**Addendum No. 1**

RE: Contract # C204815

**Davidson County (B-5783)**

BRIDGES #164 AND #168 OVER THE NORFOLK SOUTHERN RAILWAY ON  
US-29/70 I-85 BUS.

PROJECT NO. B-5783
DAVIDSON COUNTY
STATION: 21+13.32 -NBL-

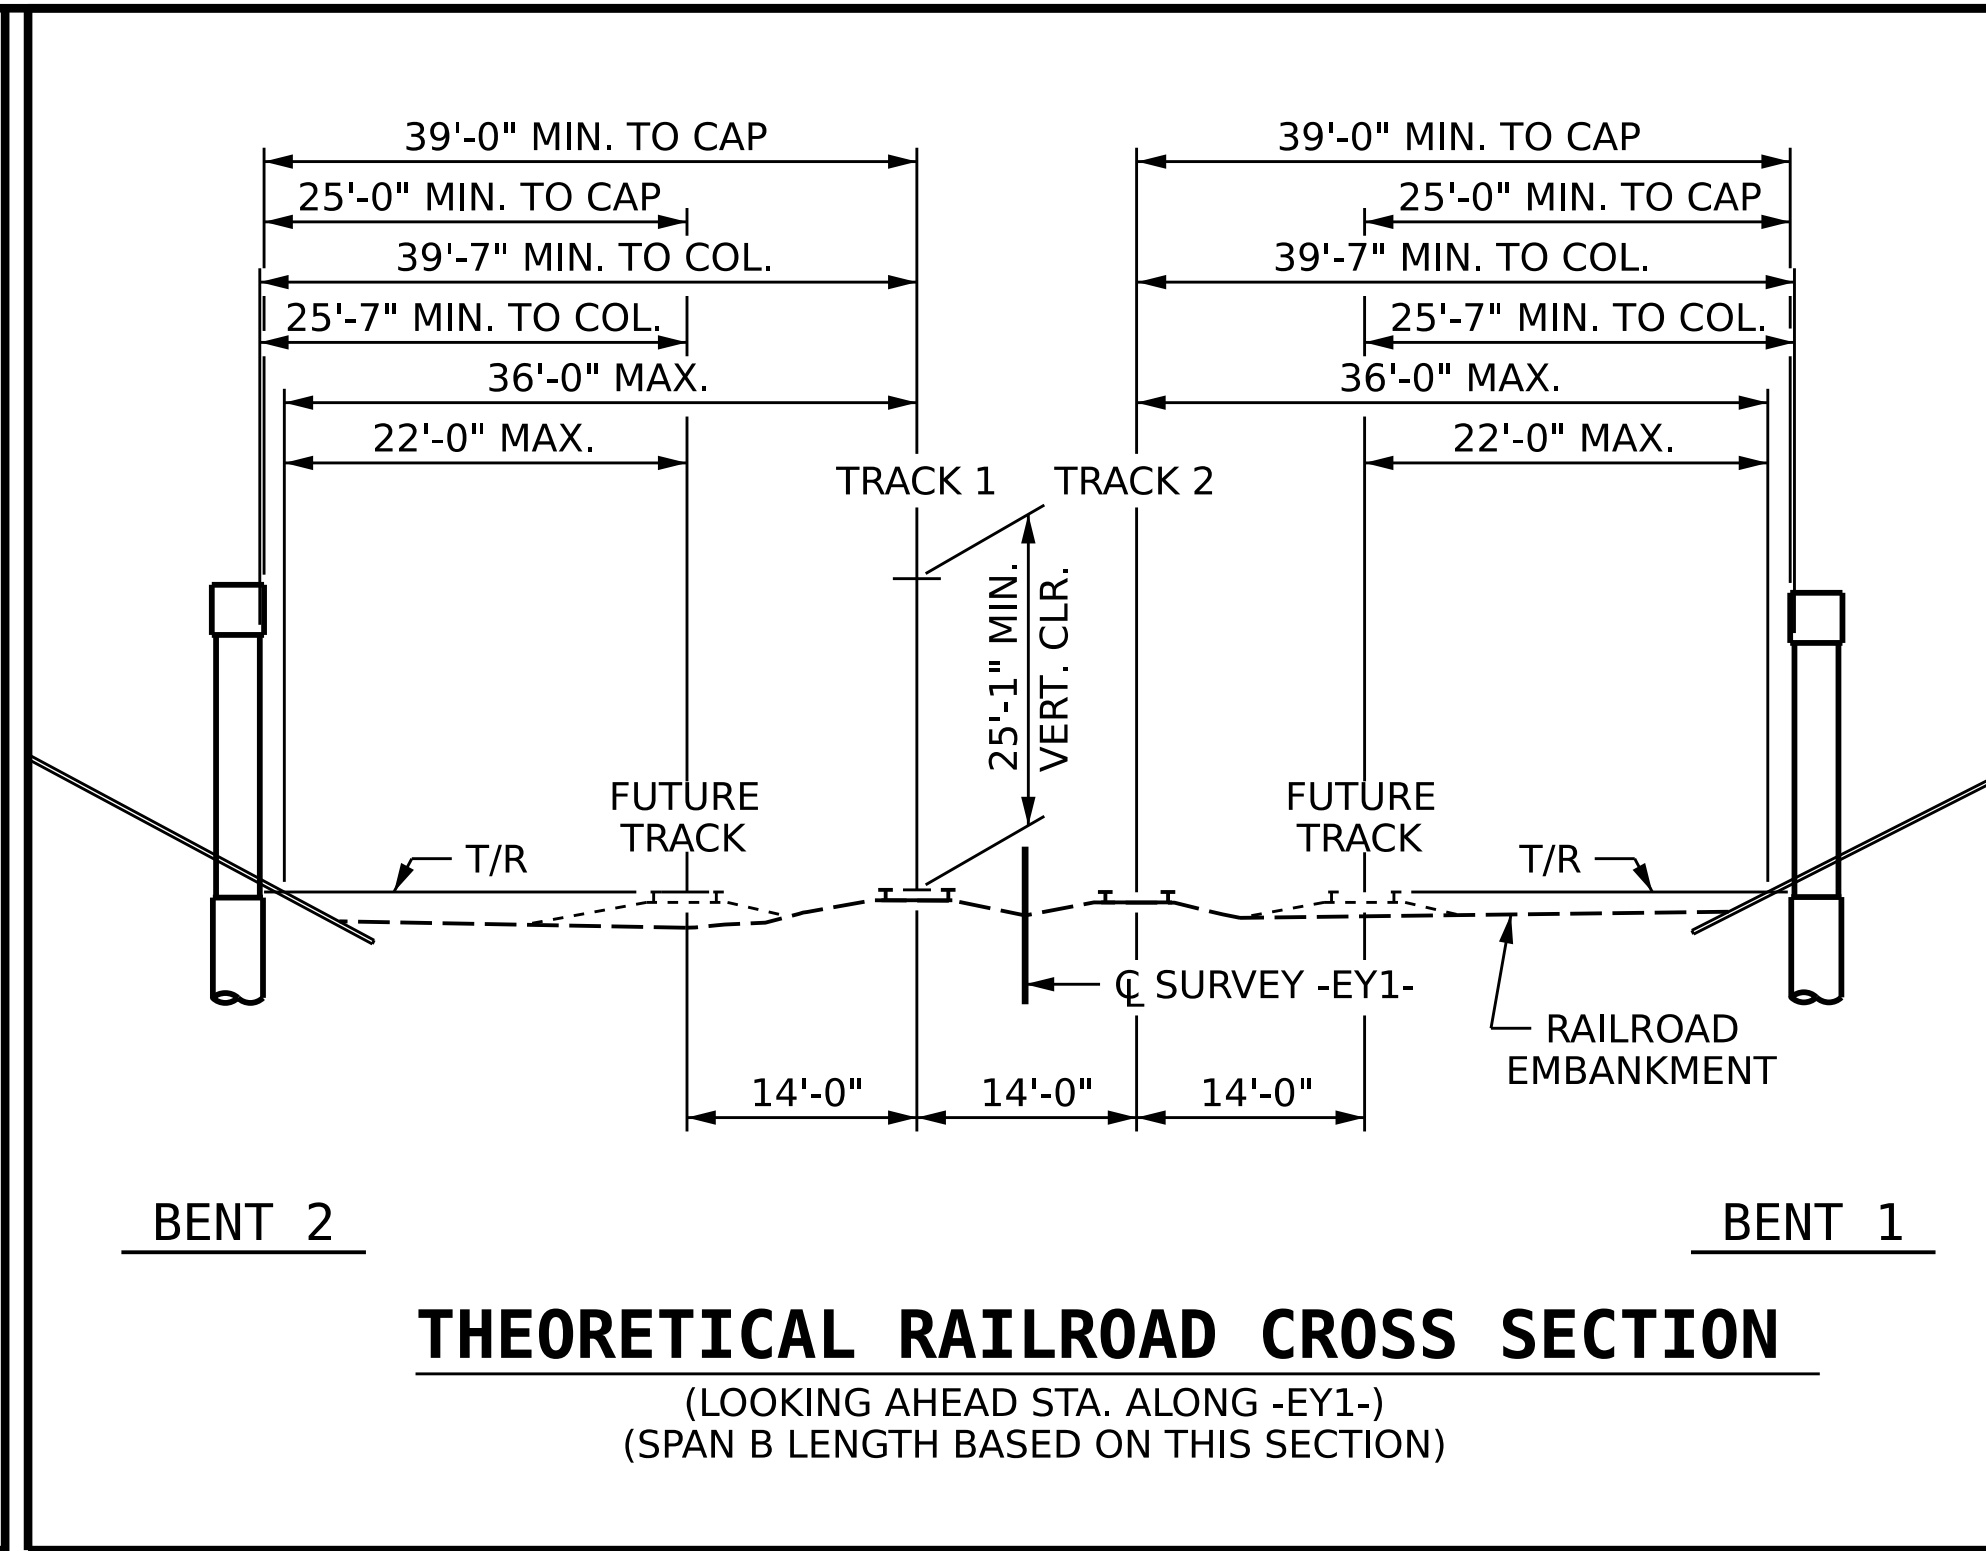
Sheet No.	Revision
S1-04, S2-04	Total Bill of Material tables updated to reflect new Class A Concrete quantities.

<u>Item</u>	<u>Description</u>	<u>Old Quantity</u>	<u>New Quantity</u>
0137-818200000-E 420	CLASS A CONCRETE (BRIDGE)	522.8 CY	411.6 CY
